November 25, 2024

SP-24-00014 MLH

After reviewing the application SP-24-00014 Kittitas County Public Health as comments. The comments are as follows:

MLH SHORT PLAT
PART OF SECTIONS 28 & 33,
T. 20 N., R. 16 E., W.M.
KITTITAS COUNTY, WASHINGTON

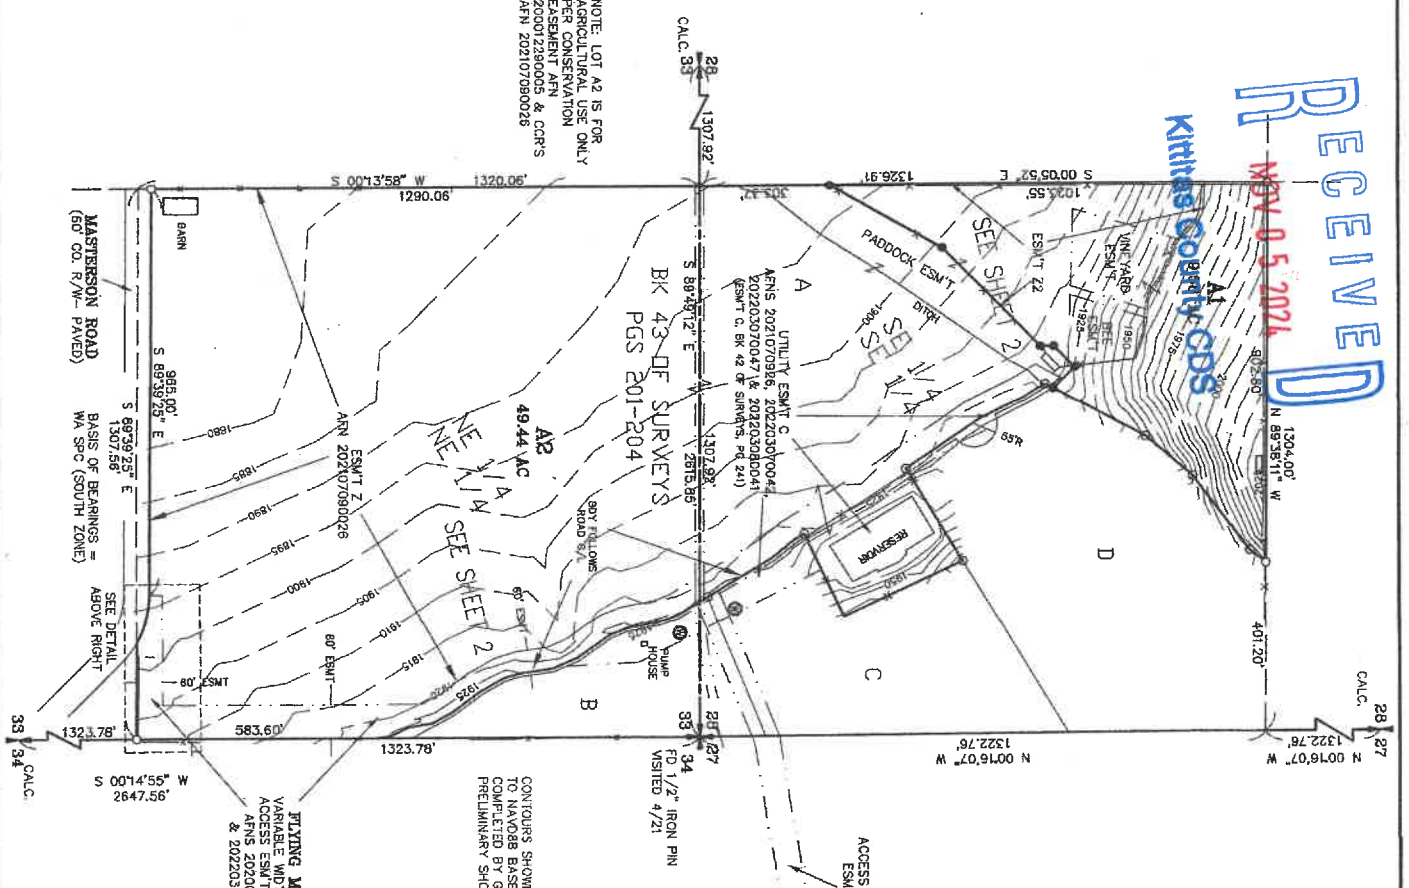
1. Lot A1 will need to submit an adequate water supply determination as well as a well log for drinking water on the lot.
2. Lot A1 will also need to submit a soil log.
